Ref: IAM/CM/1535/F

RE: Proposed 80 Bed Care Home, Mapplewell, Barnsley DHJ 6BB

Following the deferral of the above application by the committee, please find enclosed additional information to support and supplement the application.

While the application has been considered, the design development has progressed and Building Control and Engineering have had input into the design. This has led to some minor amendments to the scheme, which we enclose for your information.

Mapplewell, Barnsley  
 Architects  
 1300 @ A1 Date: Sept 11  
 Drawn: kp  
 Scale: 1:200 @ A1  
 1335 L 191 01  
 A

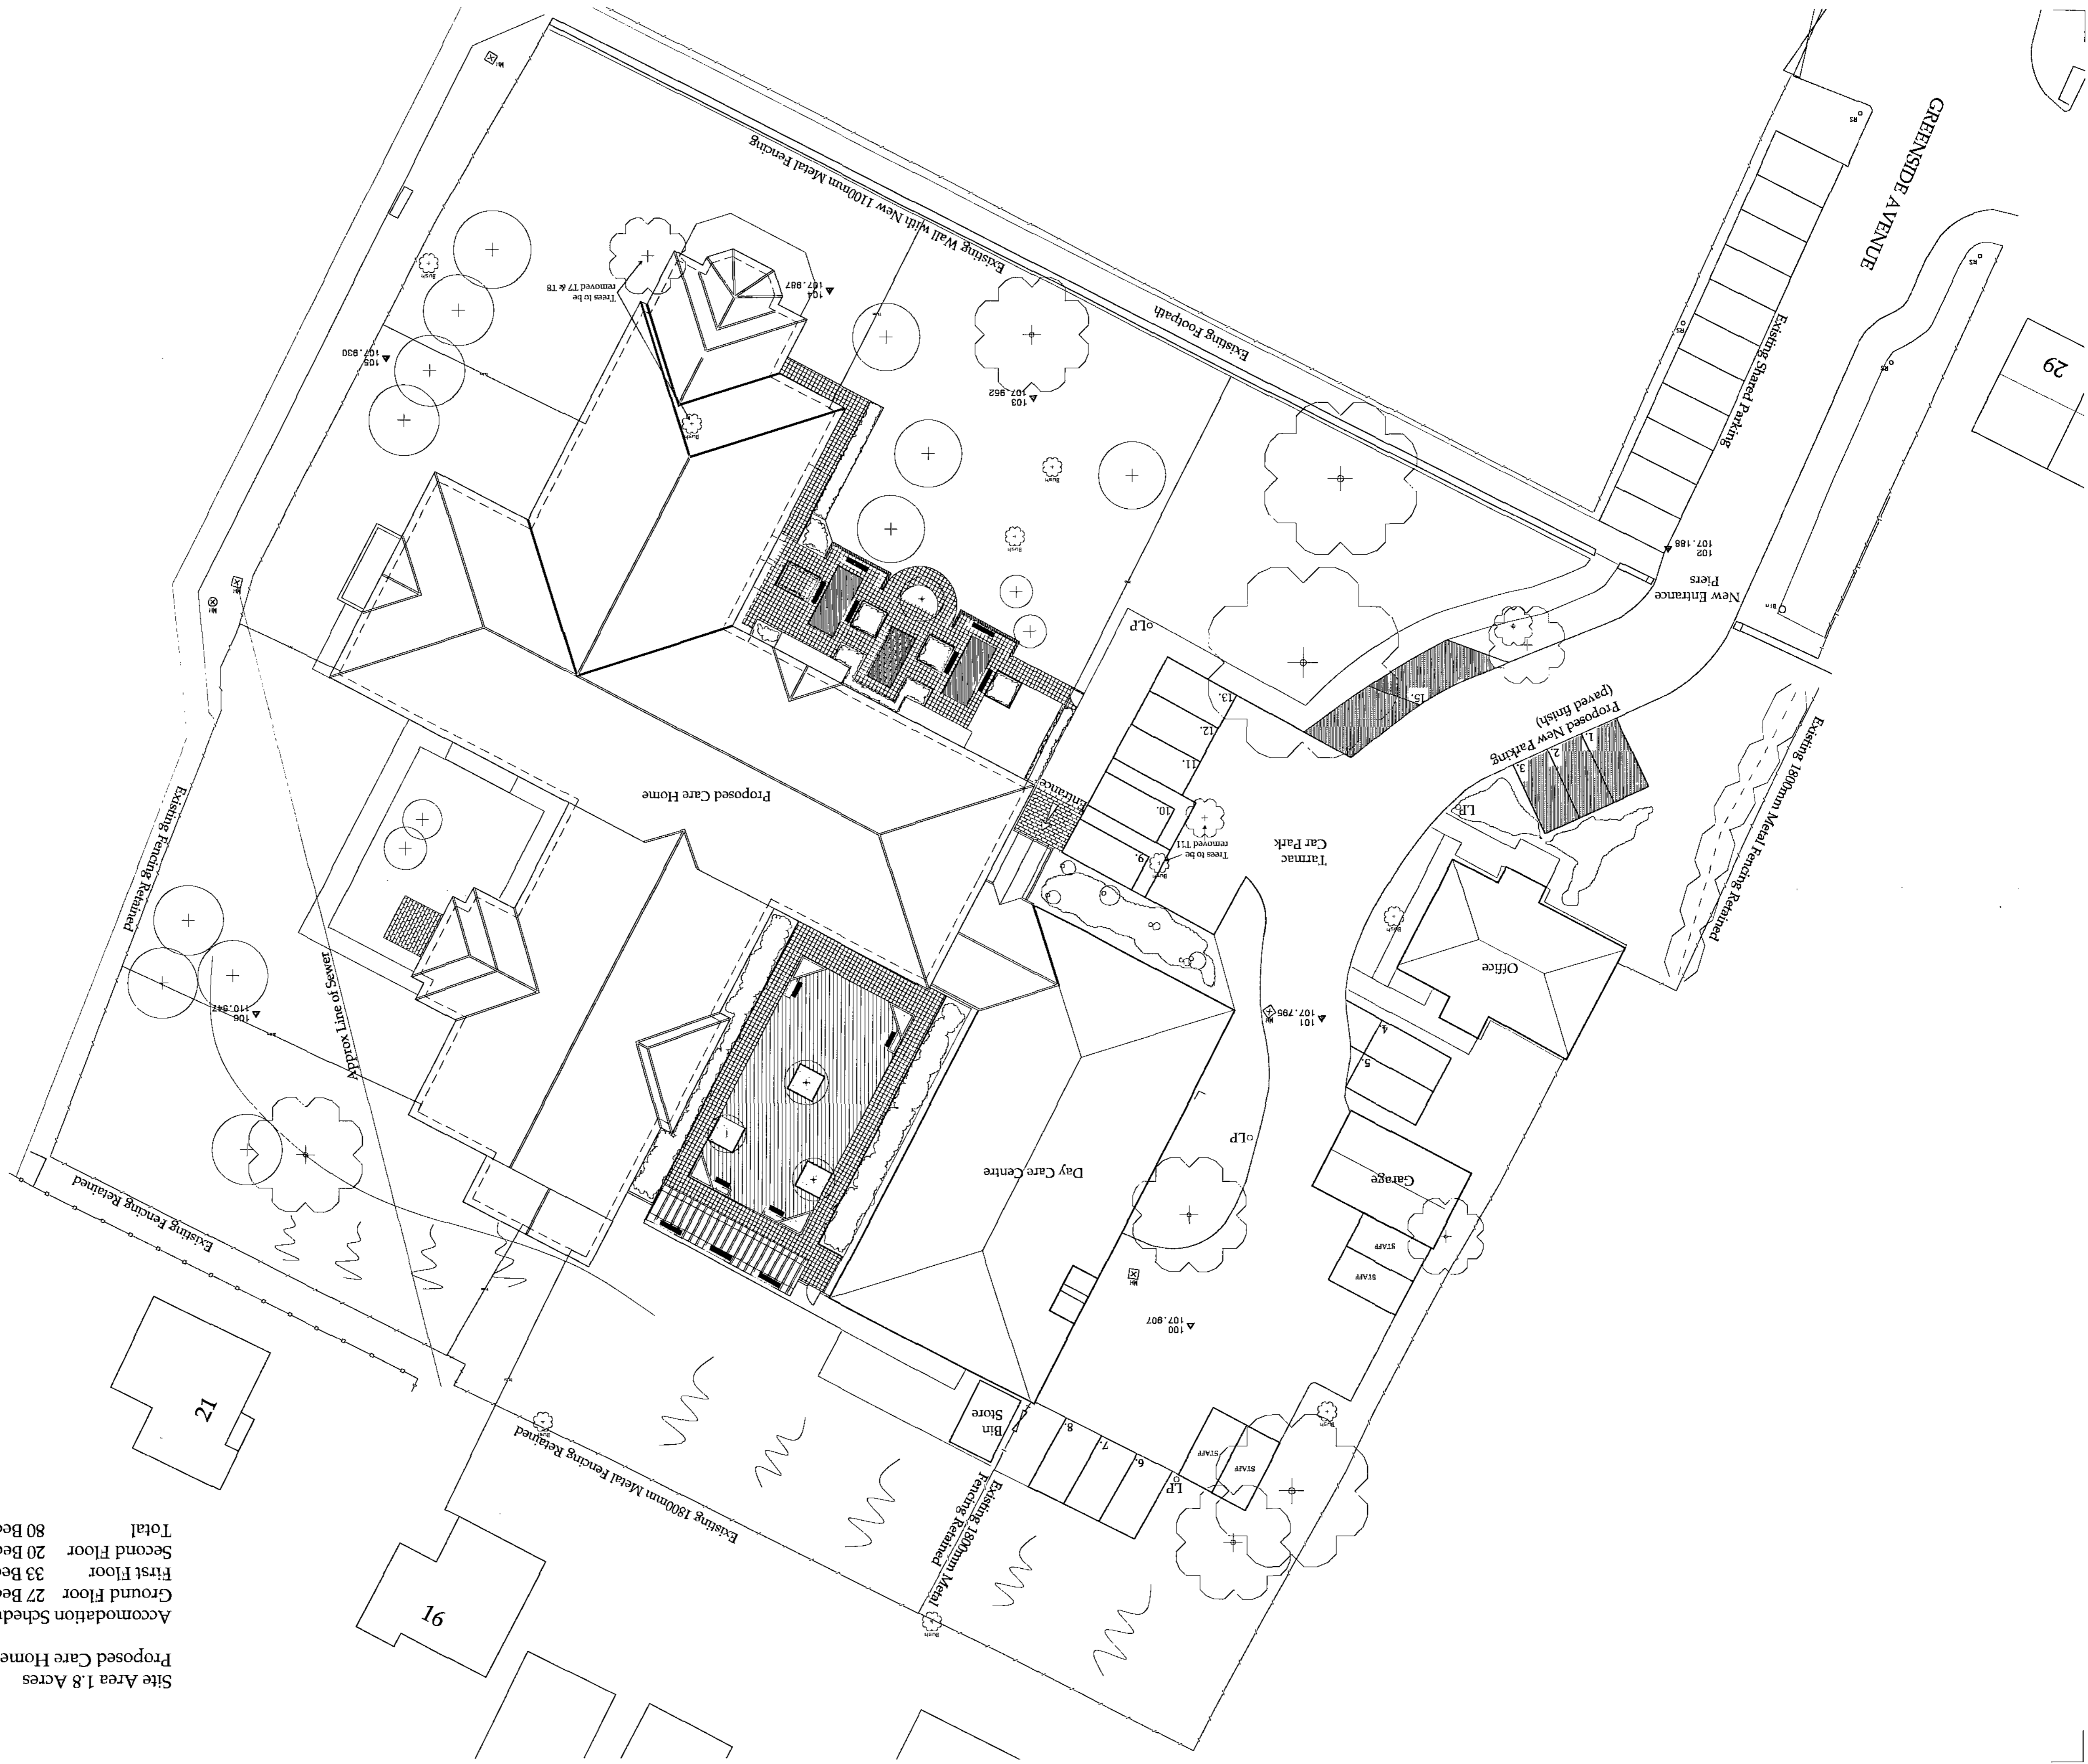
Our Application showed a parking provision on site of 15 spaces, which I believe was acceptable to Highways. The site, however, can easily accommodate more parking and we have taken this opportunity to indicate a further 4 spaces, without affecting any manoeuvring processes. In addition, the parking spaces outside the curtilage of the site are only in demand when parents drop off or collect their children. The Care Home will be organising staff start and finish times to avoid any clash with the school use, as that is the sensible way forward.

The existing access road is actually owned by the Council and they were notified as part of our Application, as our Client has a legal right of access to the Home site with an informal arrangement to use the parking on the road, provided it does not conflict with school use. Unfortunately, we outlined the access road erroneously in blue, and enclose a new site plan with our Client's ownership shown in red.

**General Arrangement  
Roof Plan**

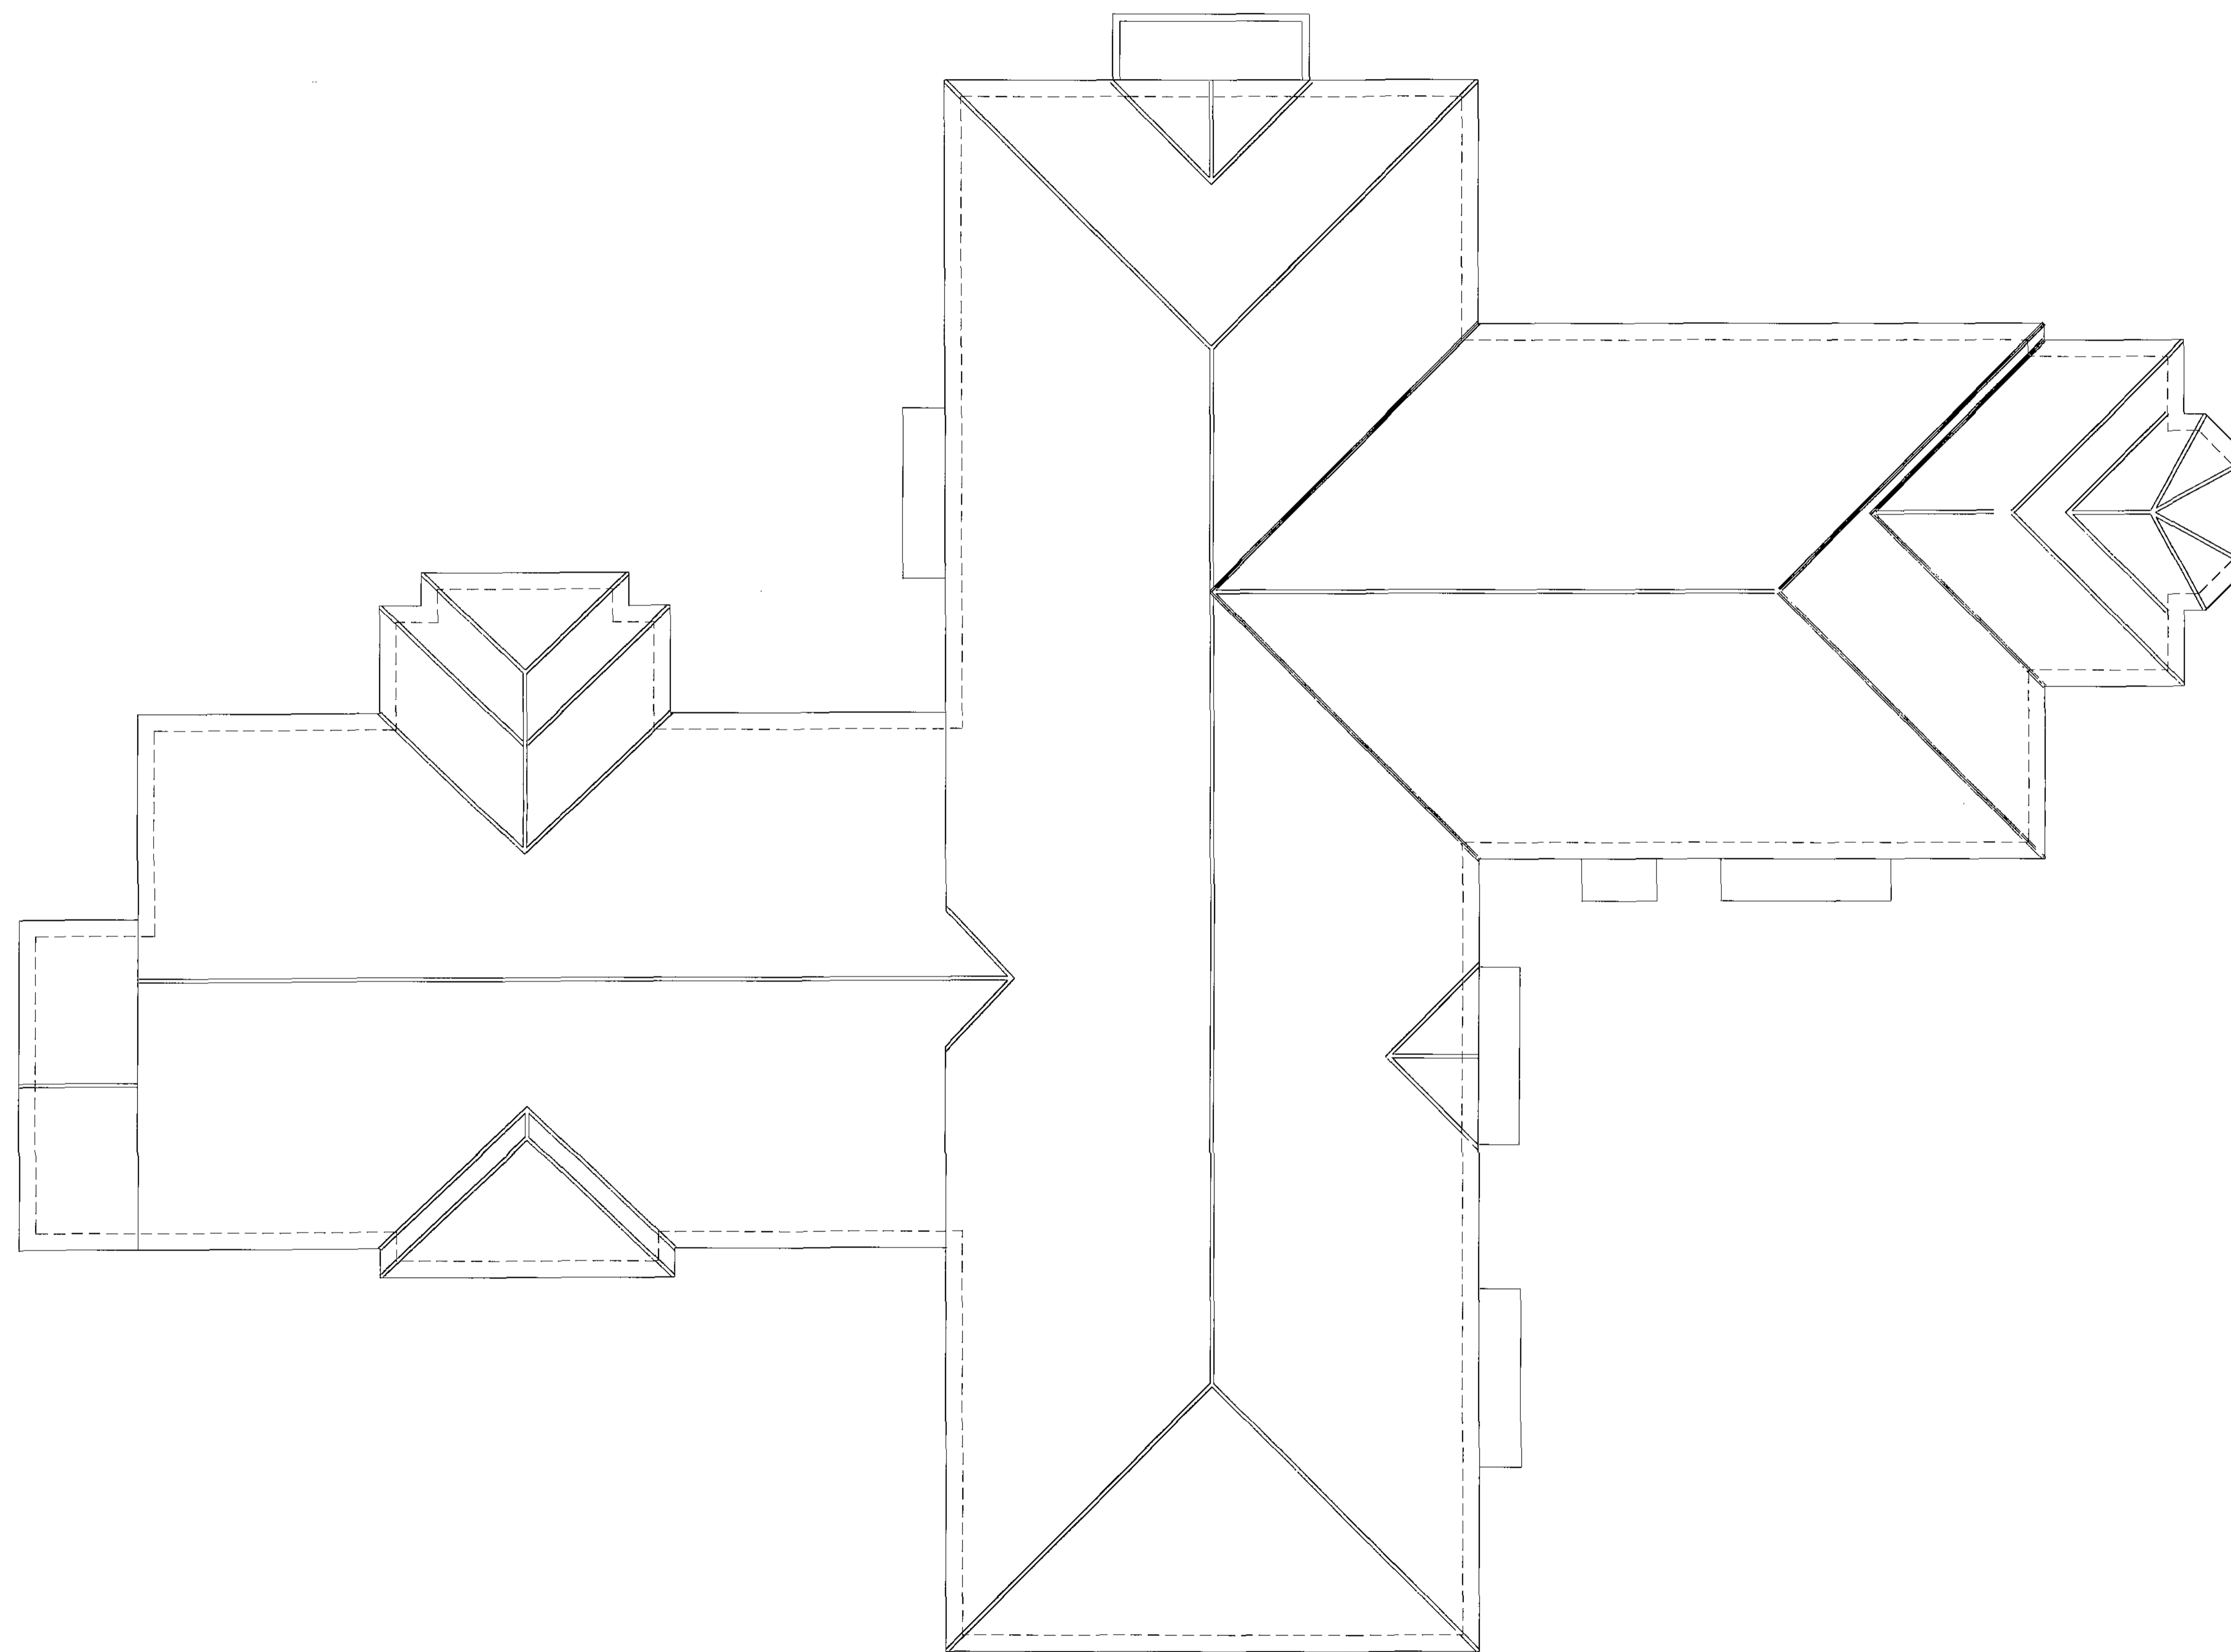
For Building Control reasons the staircase within the two storey section of the building has been repositioned, to allow for additional escape means from the second floor activity space, which requires a gable instead of a hipped roof at this end of the building. This will have no impact on any neighbouring properties and we consider this a minor amendment.

In conjunction with this, though, the design development has allowed us to reduce the height of the eaves and overall ridge height of both the three and two storey sections by 230mm.
